**Transport  
for NSW**

**Exhibition of State Significant Development Application for Bringelly Road  
Business Hub, Leppington (SSD 6324)**

Transport for NSW (TfNSW) has reviewed the documentation submitted in support of the above SSD, and provides the following comments to the Department for its consideration in determination of the subdivision application:

Drawing No.: 5

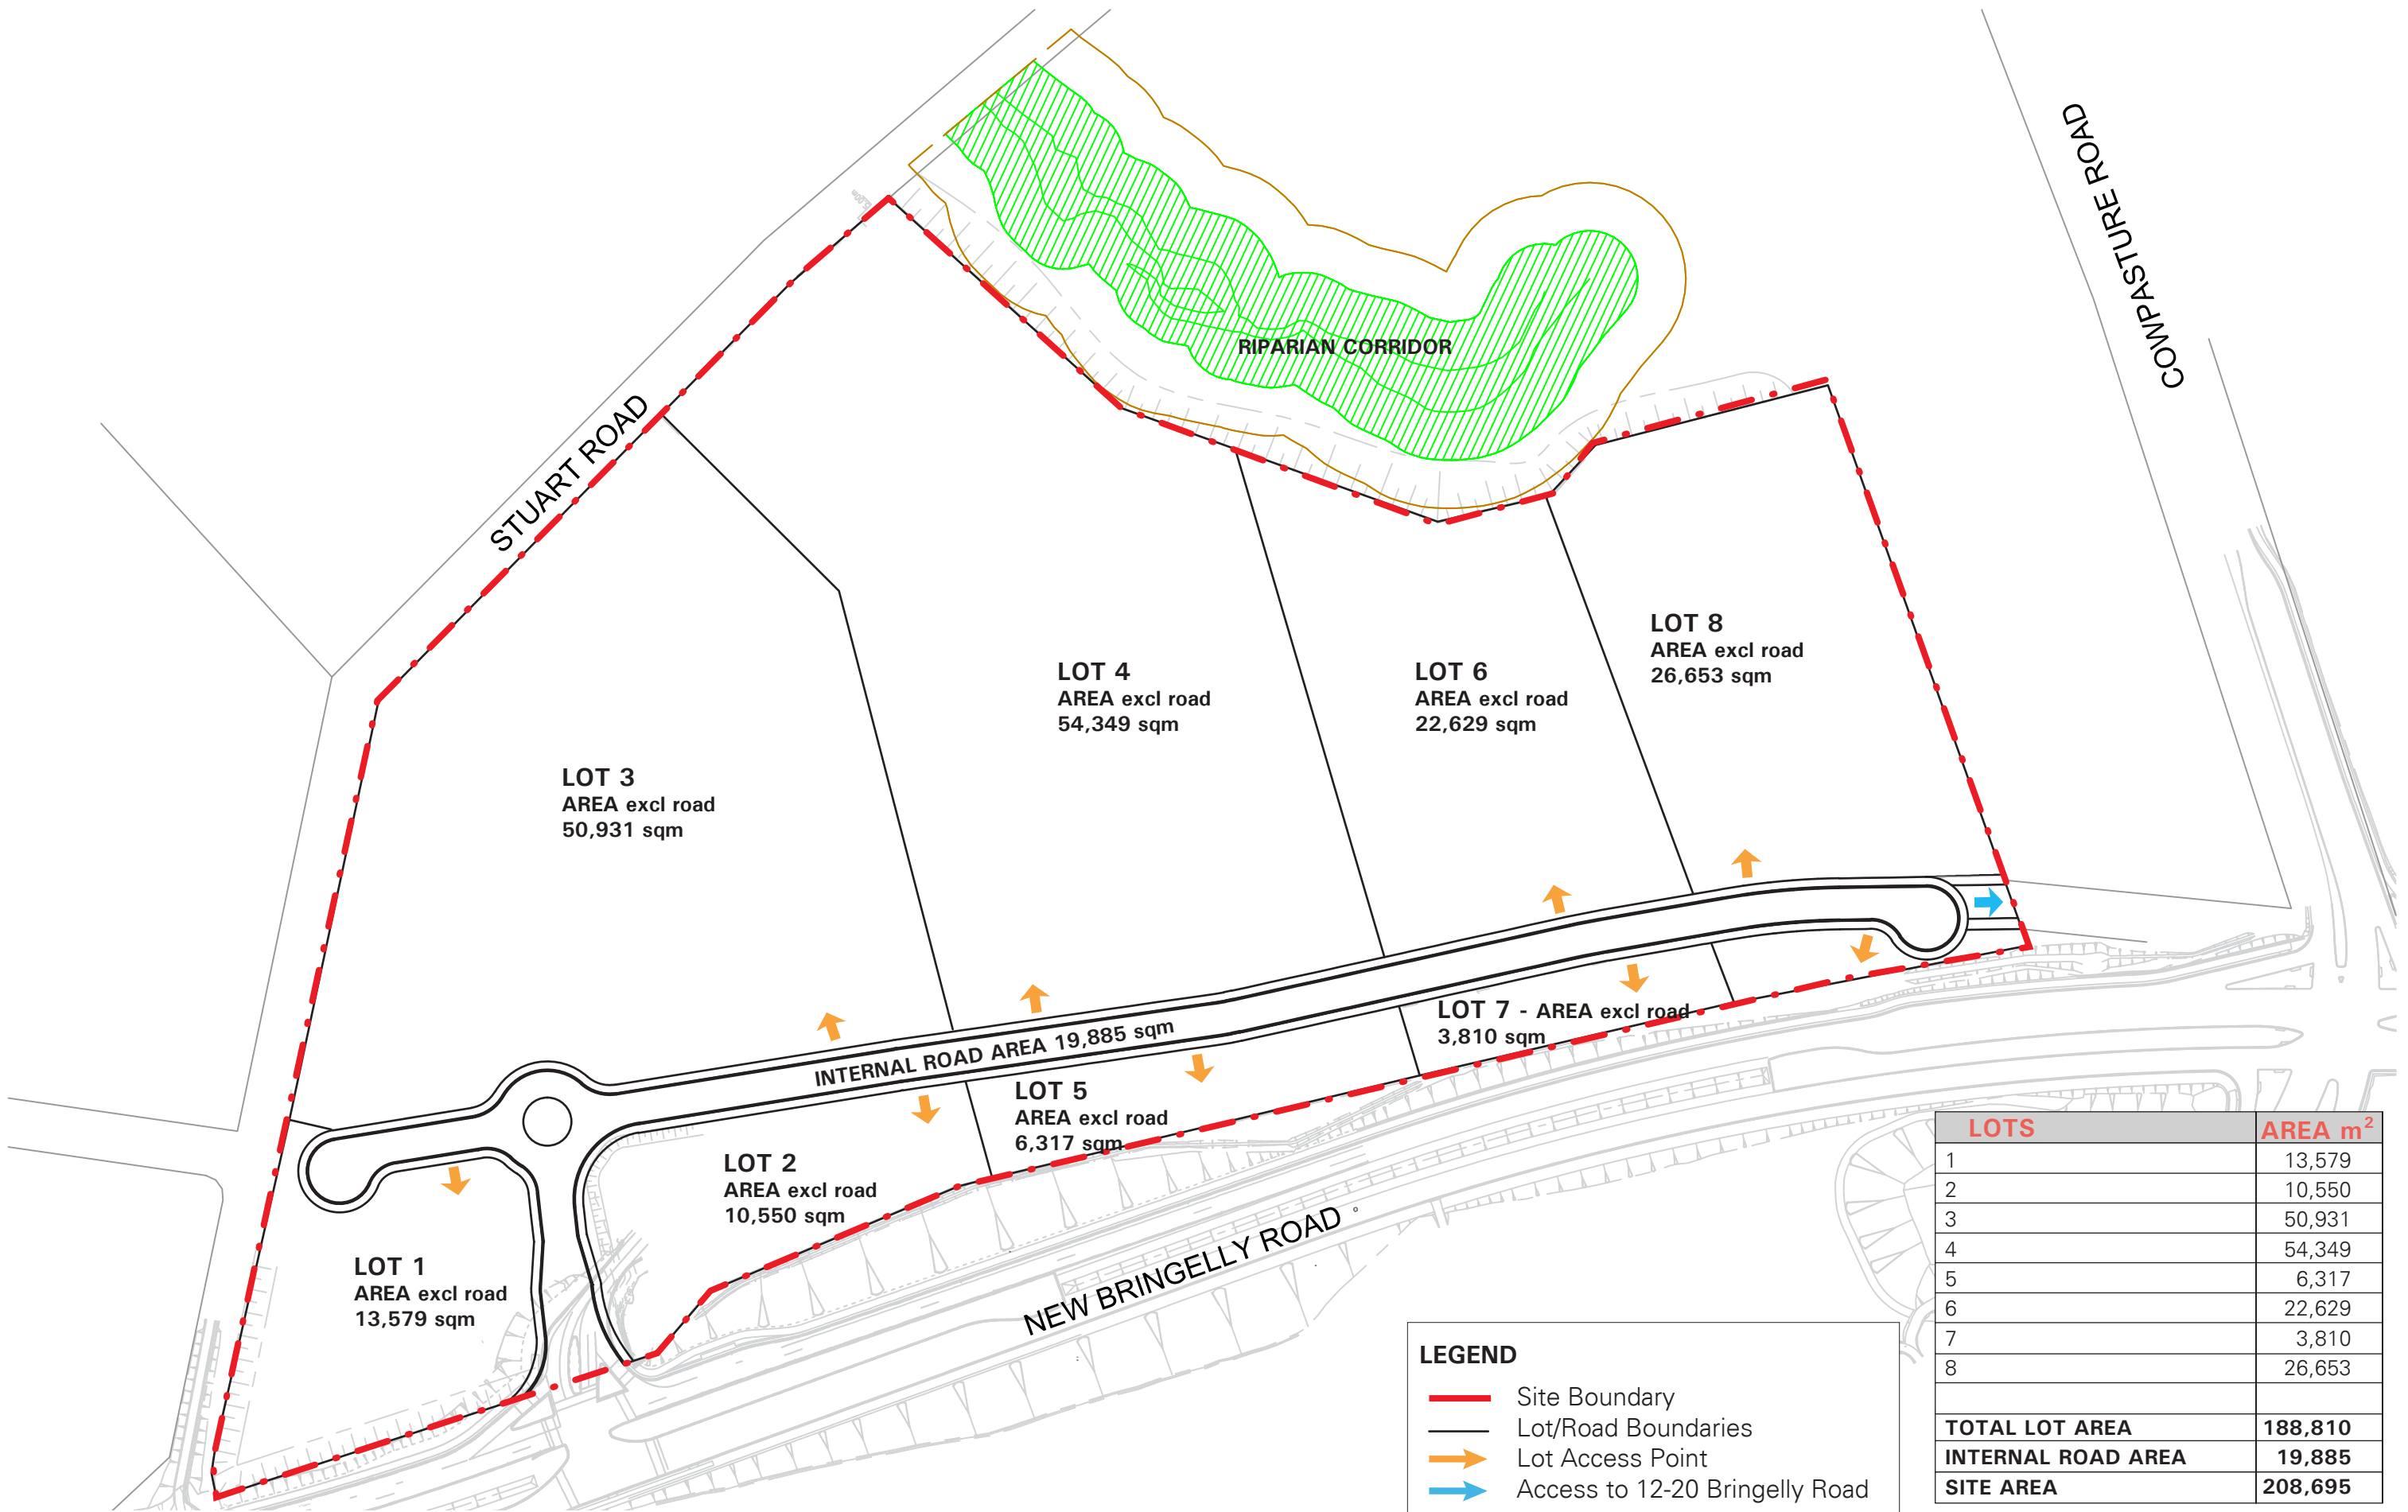
- TfNSW supports the provision of the proposed 'possible truck lane' and suggest that this be a condition of the development approval.
- The proposed 'possible truck lane' to service the large format retail sites should also accommodate access and egress for the largest vehicle anticipated to source this site.
